Re: PA22-044 – Olympic Vista PRD – Technical Review 1
4128 Sunnyside Blvd. APN 29050300102200

BINDING SITE PLAN / PLANNED RESIDENTIAL DEVELOPMENT COMMENTS

RE: Olympic Vista PRD, File# PA22-044
23 lot PRD subdivision
4128 Sunnyside Blvd. & Parcel # 29050300102200

KEYSTONE LAND, LLC.
OLYMPIC VISTA PRD
 ROAD, STORM DRAINAGE AND GRADING PLAN

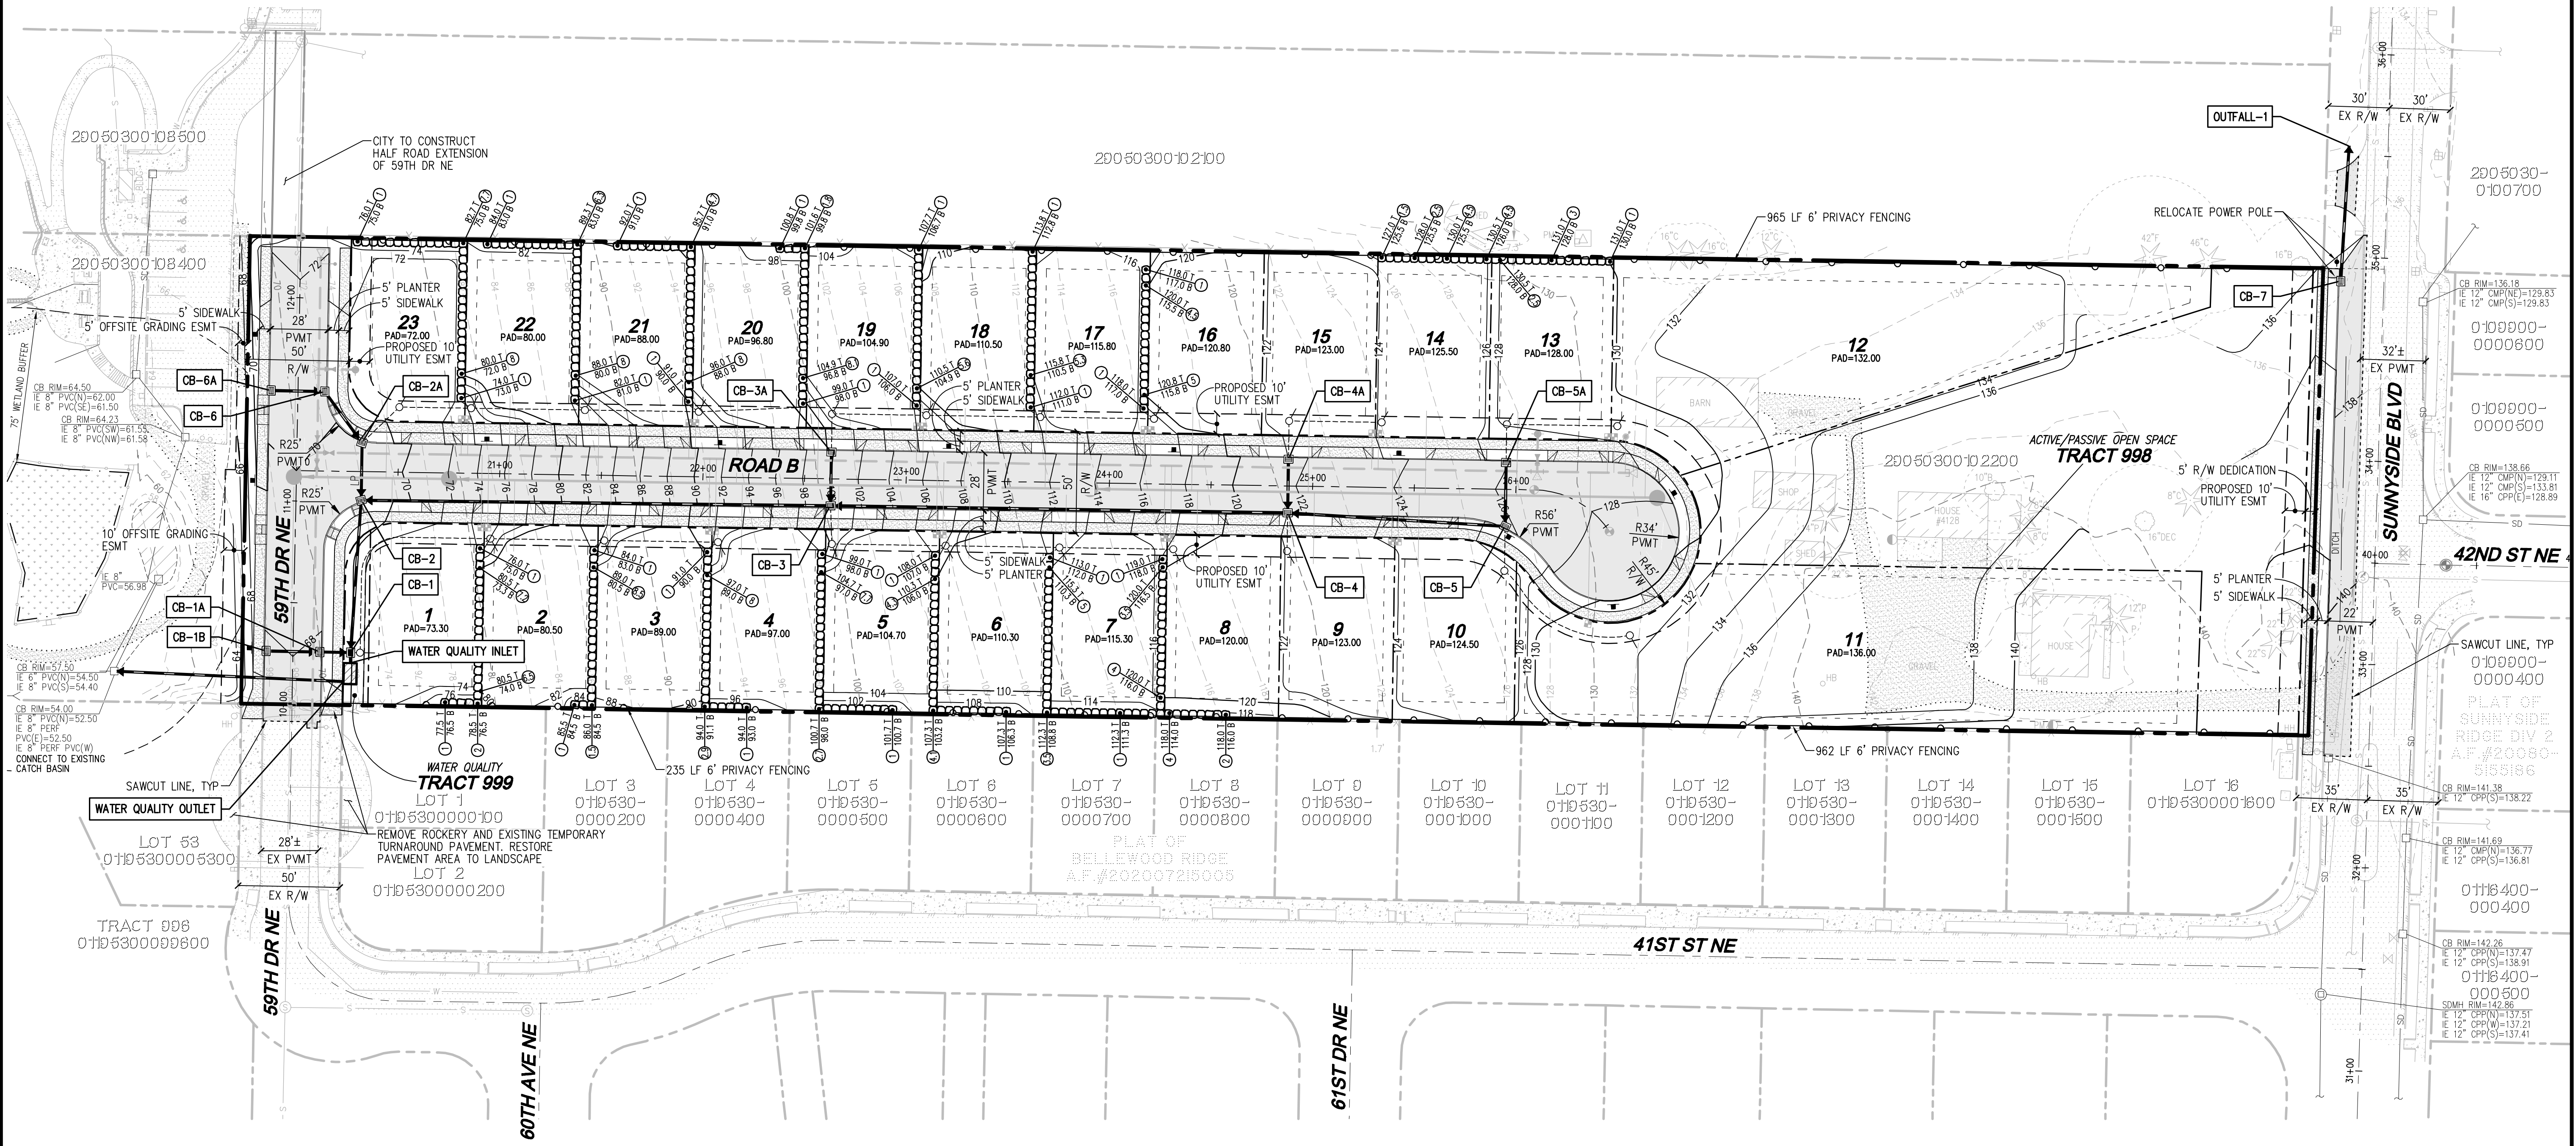
17. Please remove the note on Sheet 4 of the preliminary civil plans referencing City construction of half-road extension. This is not part of this project and has caused confusion.

Thank you both. From a Parks perspective, the only comment that comes to mind regards the retaining wall along the west side of 59th. The roadway cross section shows the base of the wall at the ROW/property line. The City should anticipate the establishment of an wall maintenance access easement in favor of the City onto the OVP parcel, likely about 10-15 feet depending on how thing dimension to the existing OVP parking lot. This simply precludes any issues with a "100 year" perspective should OVP's use change in the future.

I'll only otherwise mention that with the steep on-site Road B slope towards 59th and the retaining wall on the opposite of 59th that civil reviewers should anticipate any vehicular fall-protection needs or at least object marker signs on the west side of the roadway. This may or may not be necessary but is a design detail to be worked through later.

SHEET  
**L-1**  
 OF 3

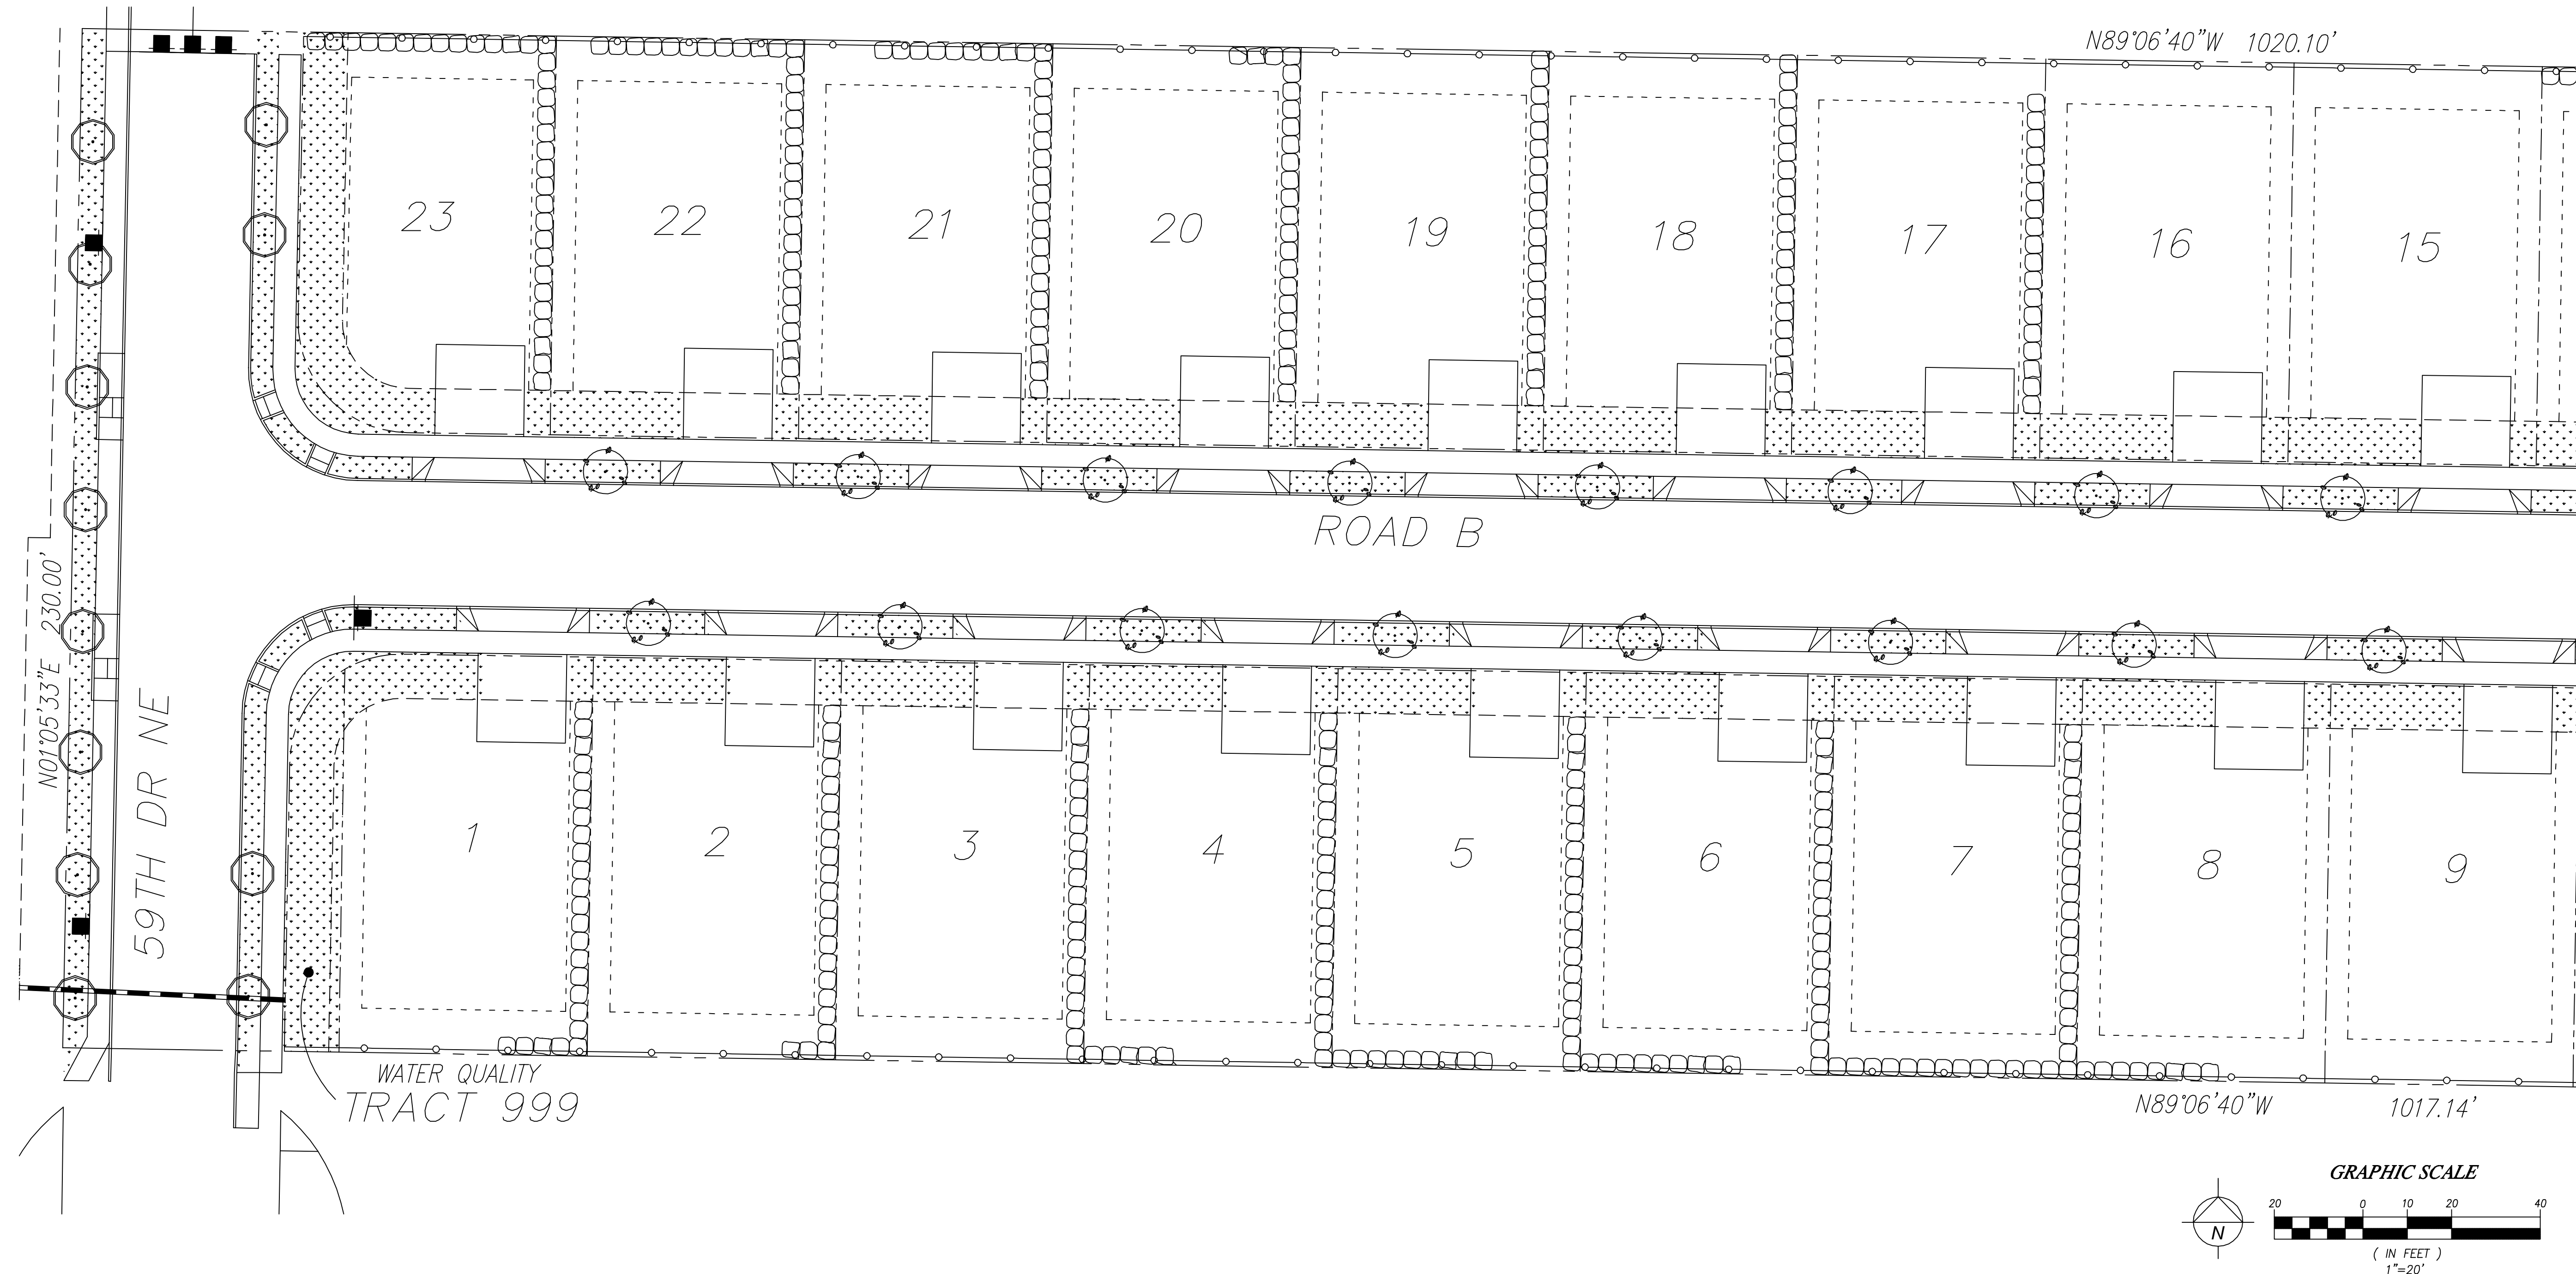
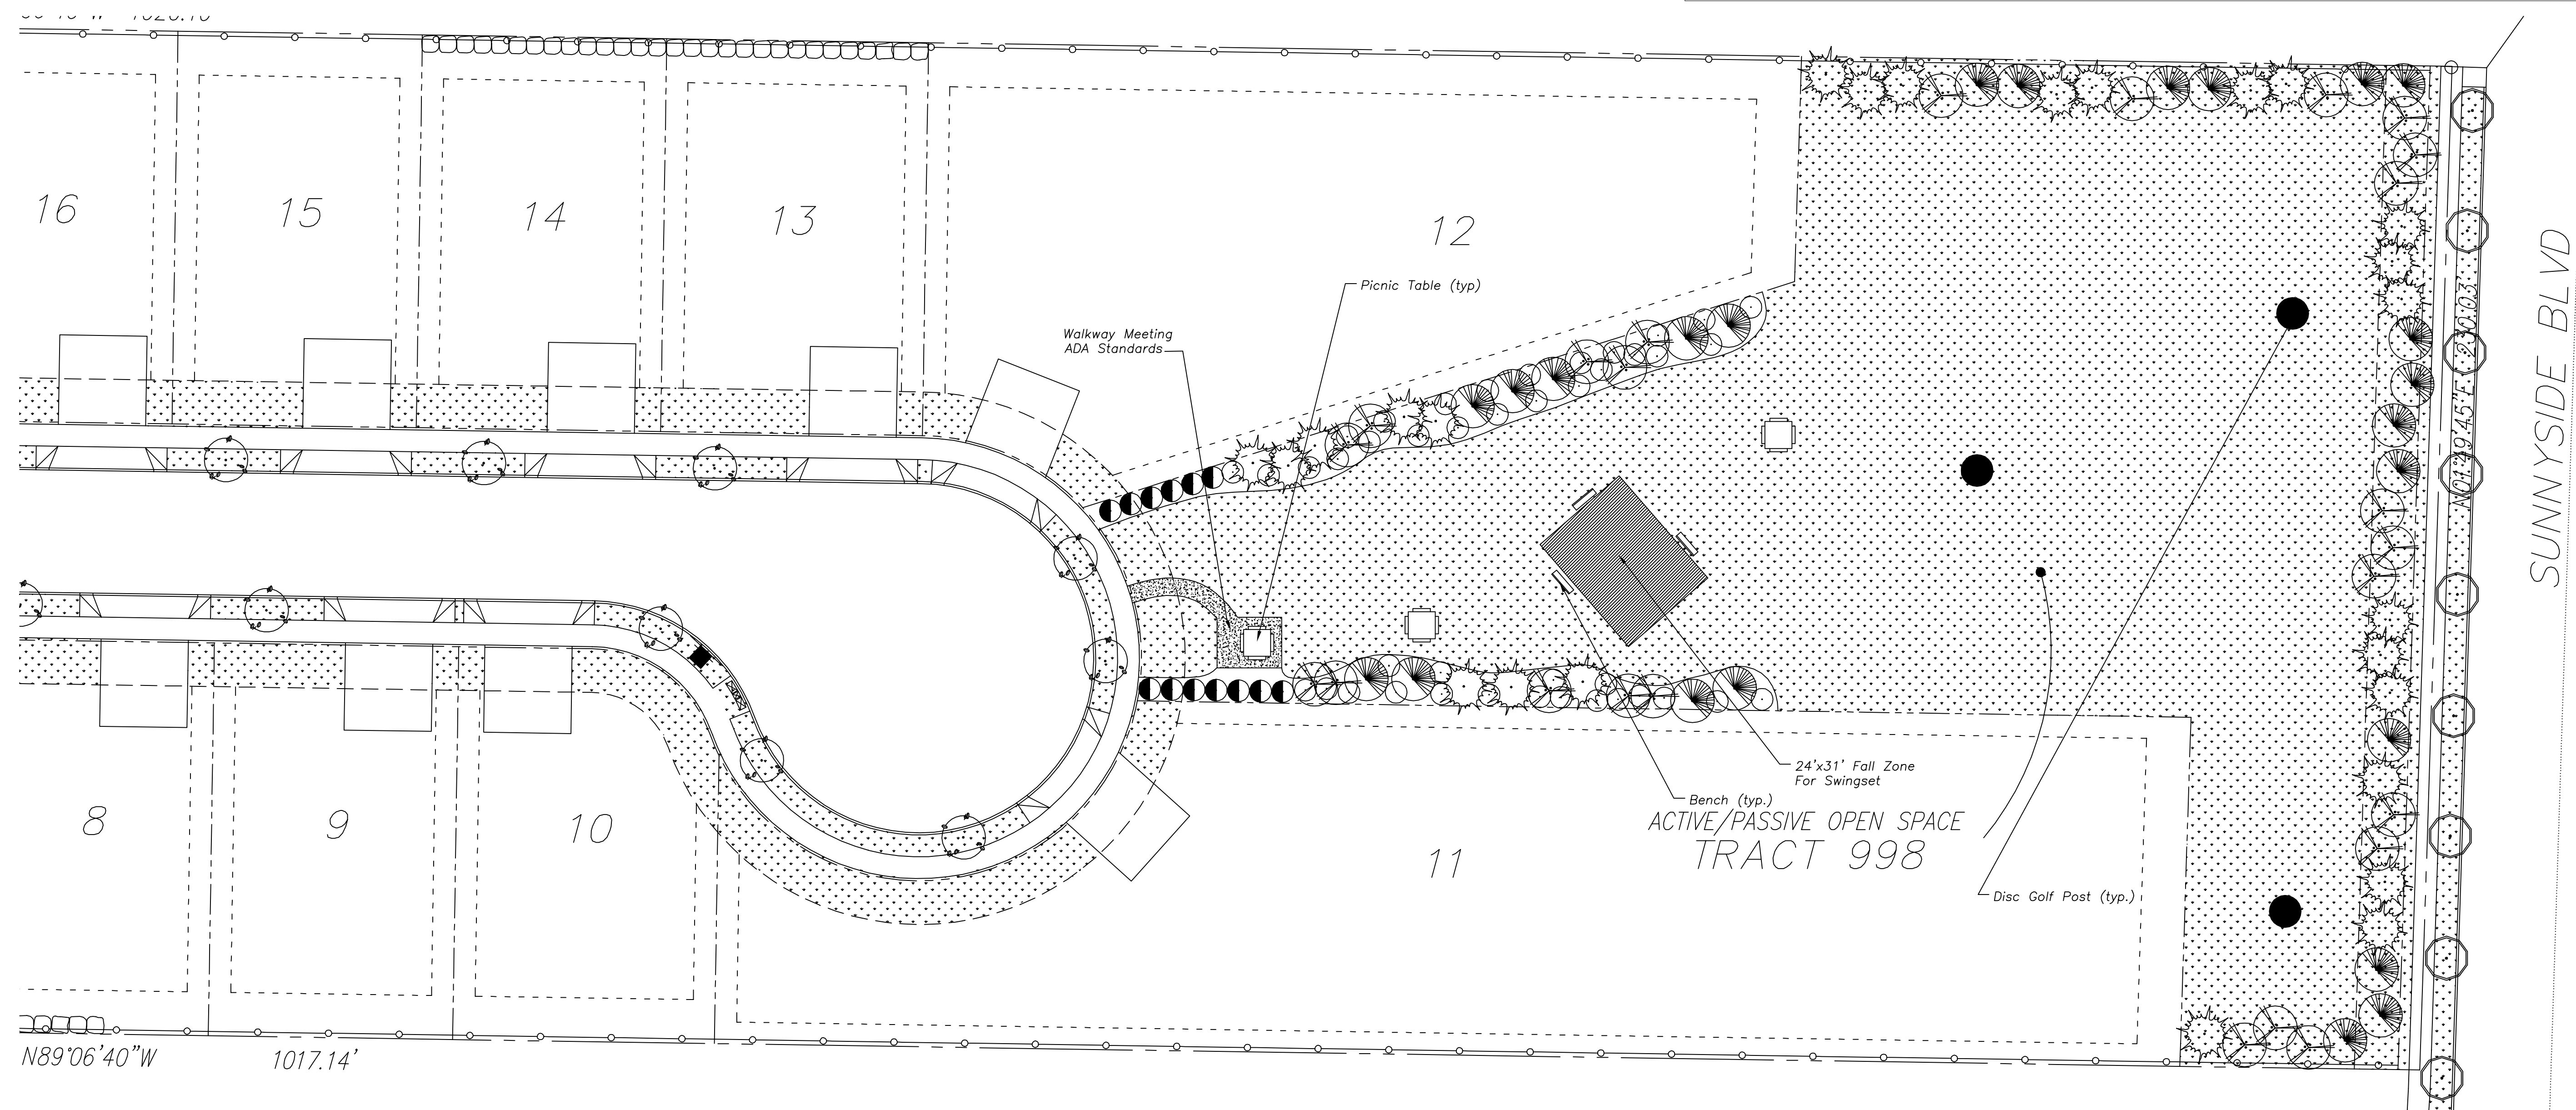
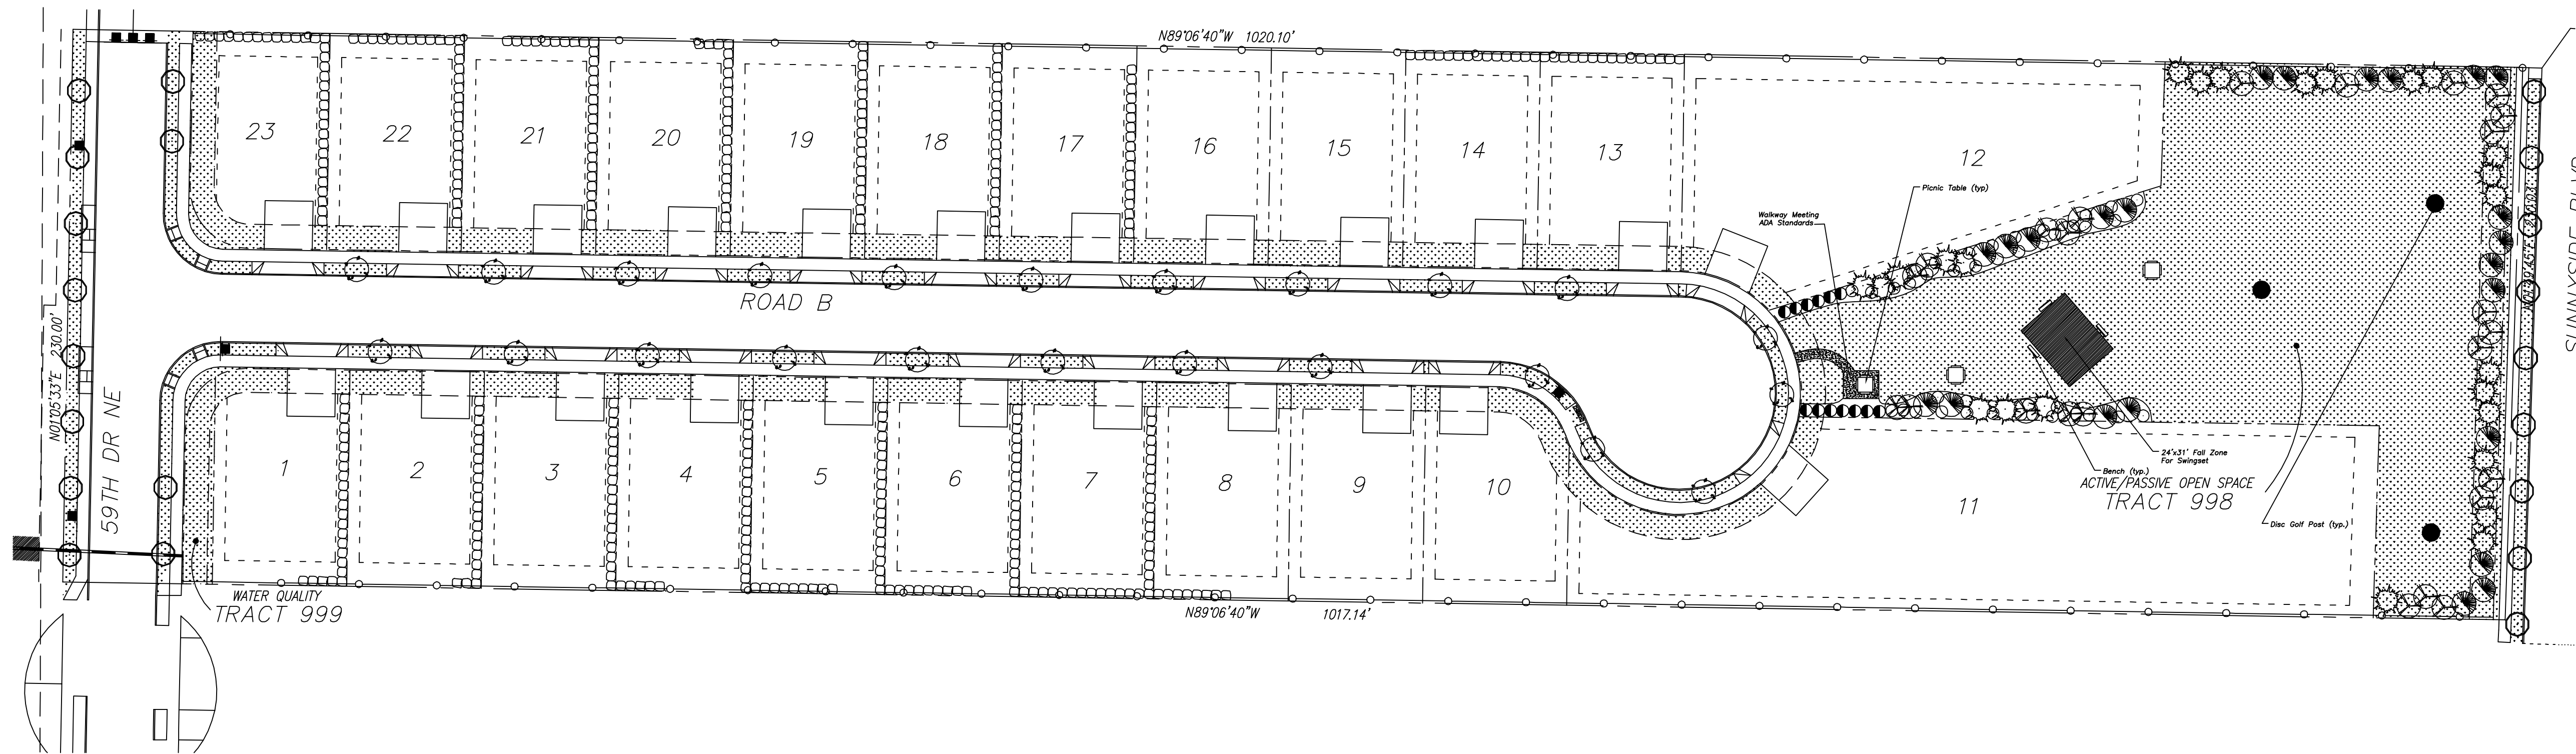
11. Sheets 9-11 (L-1, L-2, and L-3) of the Preliminary Civil Plans are not consistent with the proposed layout of the project. Please revise to be consistent with the current proposed layout.
12. A final landscape plan shall be required to be approved, prior to civil construction plan approval, and designed to comply with the applicable provisions outlined in [MMC Chapter 22C.120, Landscaping and Screening](#). **Specifically, please revise the Landscaping Plan to include:**
 - 12.1. Provide details of the plantings in Tract 999. Is the intent for it to be all turf? Does this provide the required water quality treatment?
 - 12.2. Street trees on 59th Drive NE should be the same species as those planted in the subdivision to the south.

12.3. The Parks Maintenance Supervisor has suggested using a powder coated playset to ensure that it can be easily cleaned and maintained.
